# CITY OF ALBUQUERQUE

December 10, 2012

**Re: 900 Griegos Road Townhomes Grading and Drainage Plan  
Engineer's Stamp date 12-10-12 (F-14/D067)**

ENGINEER'S SEAL  DAVID SOULE P.E. #14522	900 GRIEGOS ROAD TOWNHOUSE PROJECT	DRAWN BY WCHU
	GRADING AND DRAINAGE PLAN	DATE 11-15-12
	 Rio Grande Engineering 1808 CENTRAL AVENUE SUITE 201 ALBUQUERQUE, NM 87106 (505) 872-0999	21258-LAYOUT-11-15-12
		SHEET #
		JOB # 21258

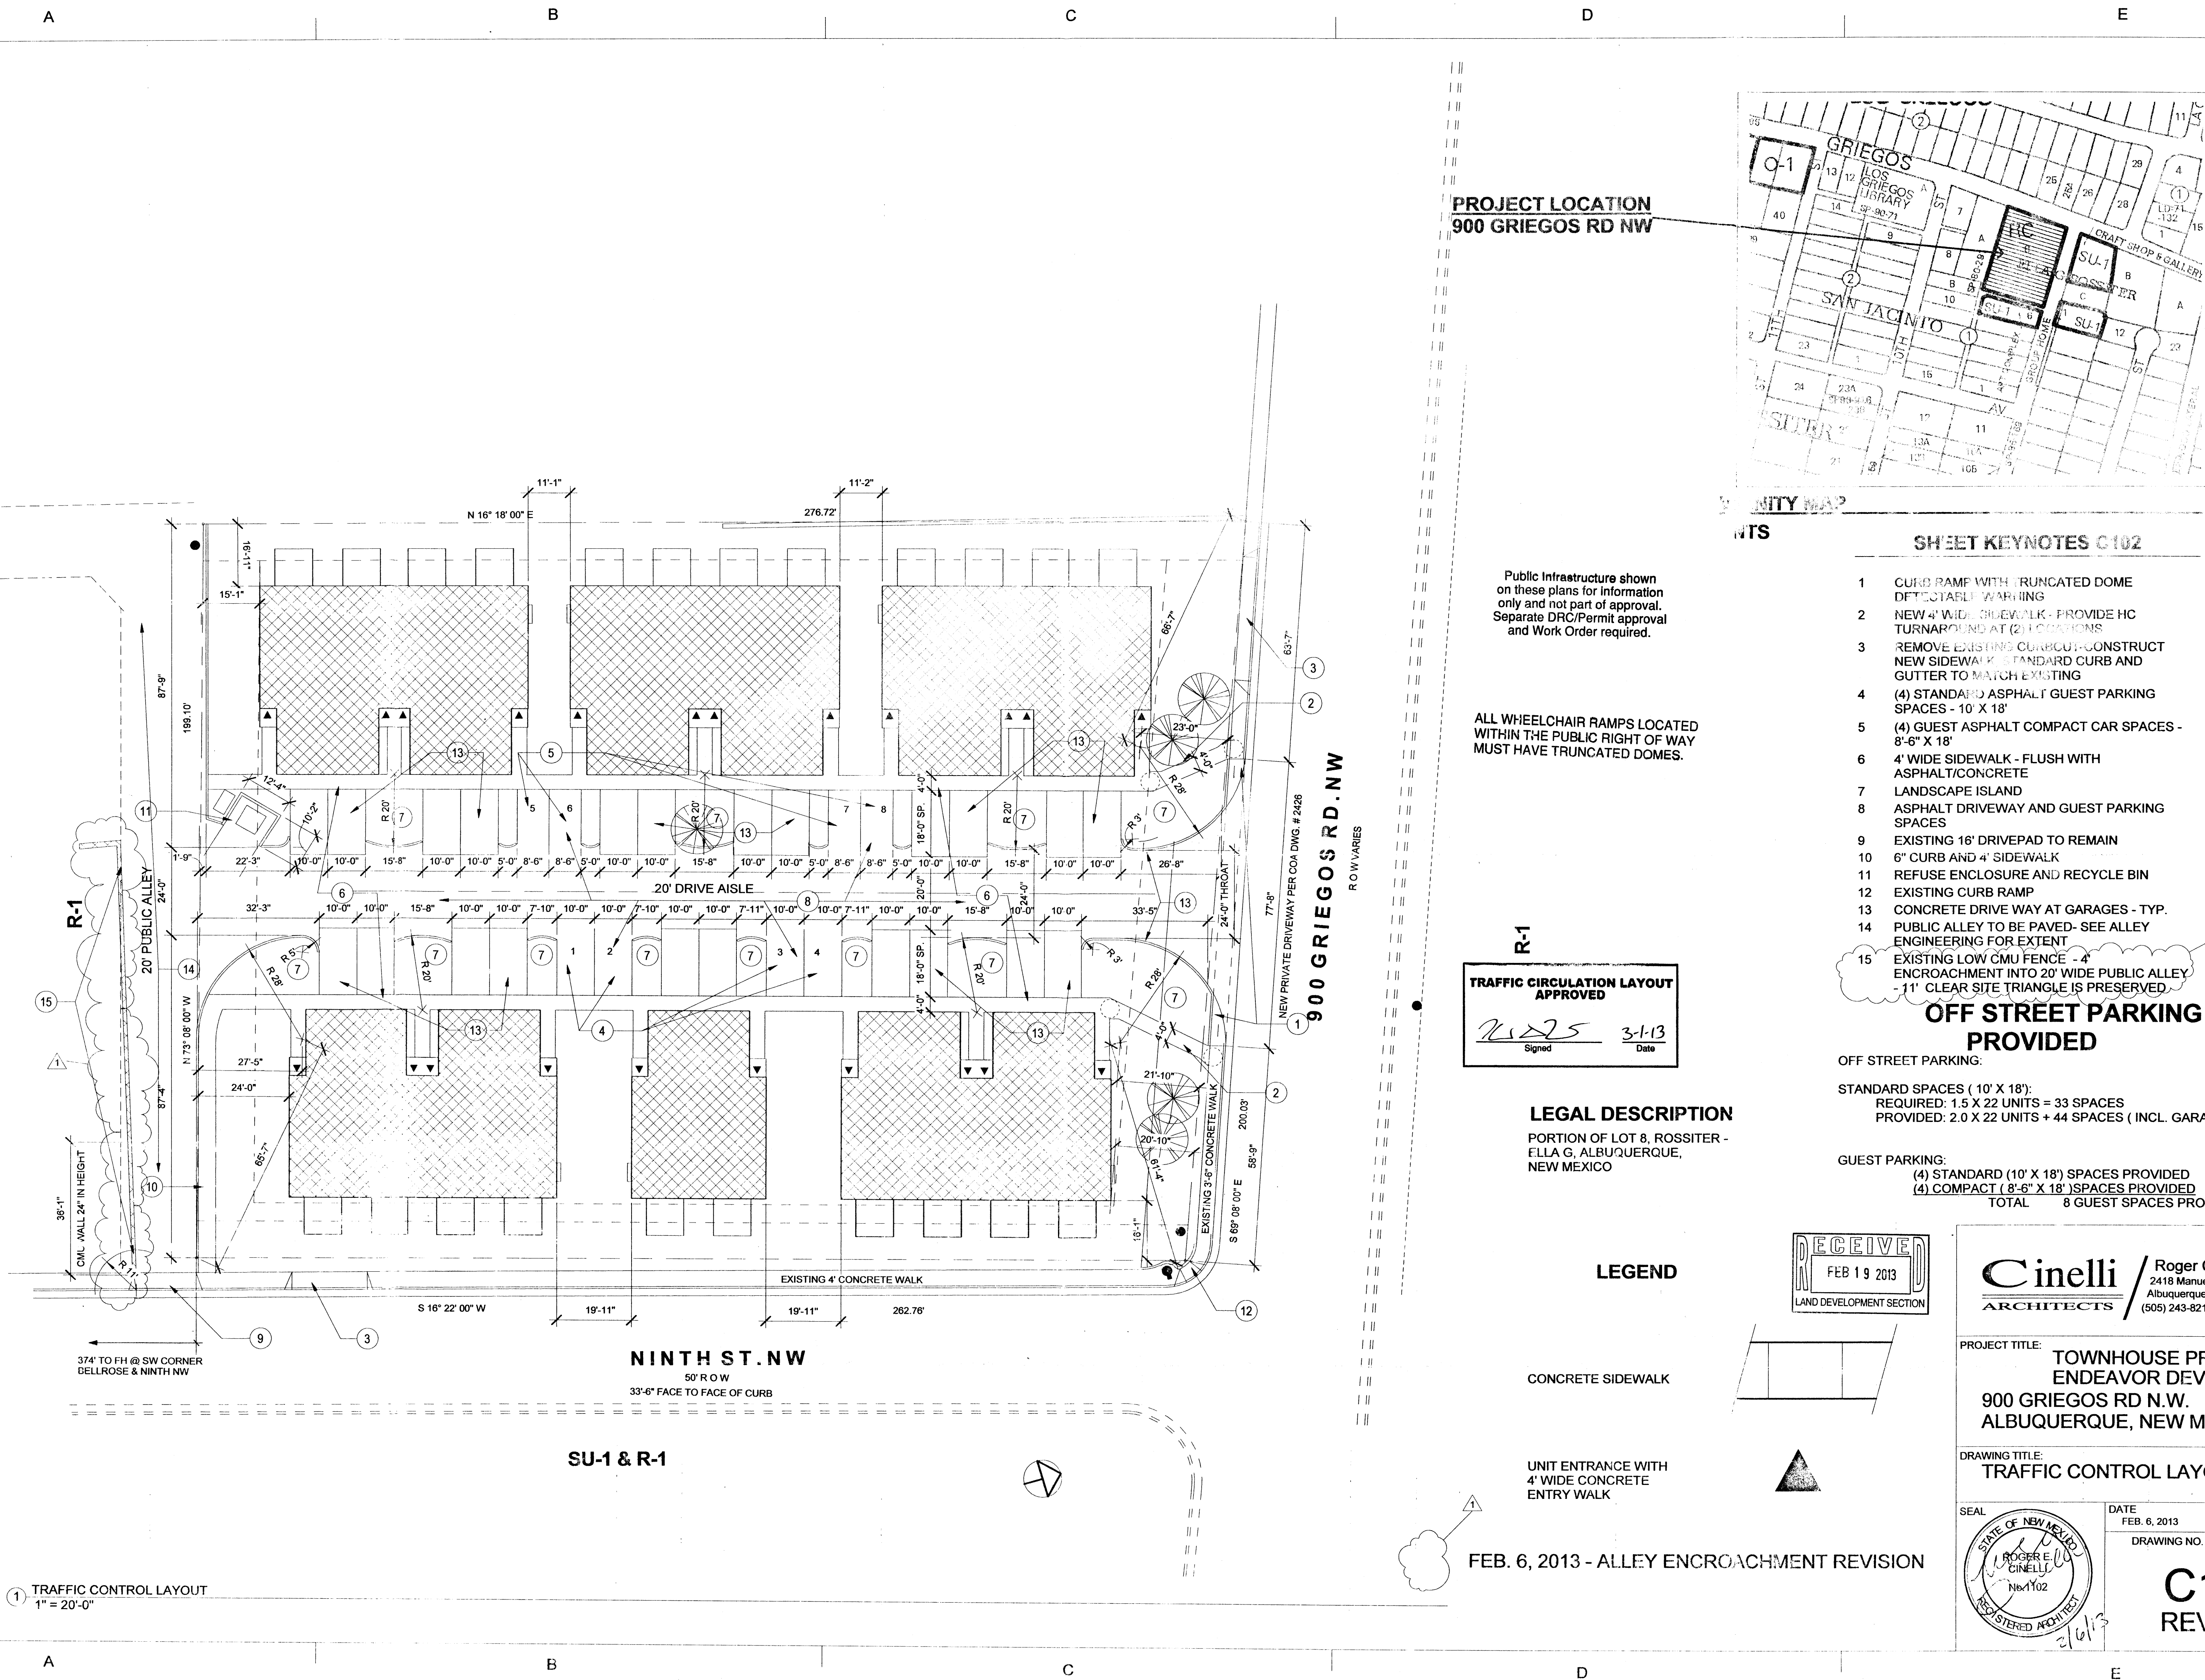
- Please make sure that the as-built elevations clearly will show the bottom elevation (4972.00) for the proposed pond at the southeast corner of the property.
- The 3-3" PVC note by the northeasterly pond is not pointing to the correct location. Please make sure that the pipe will be placed at the correct location.
- The alley should be constructed through a work order process.
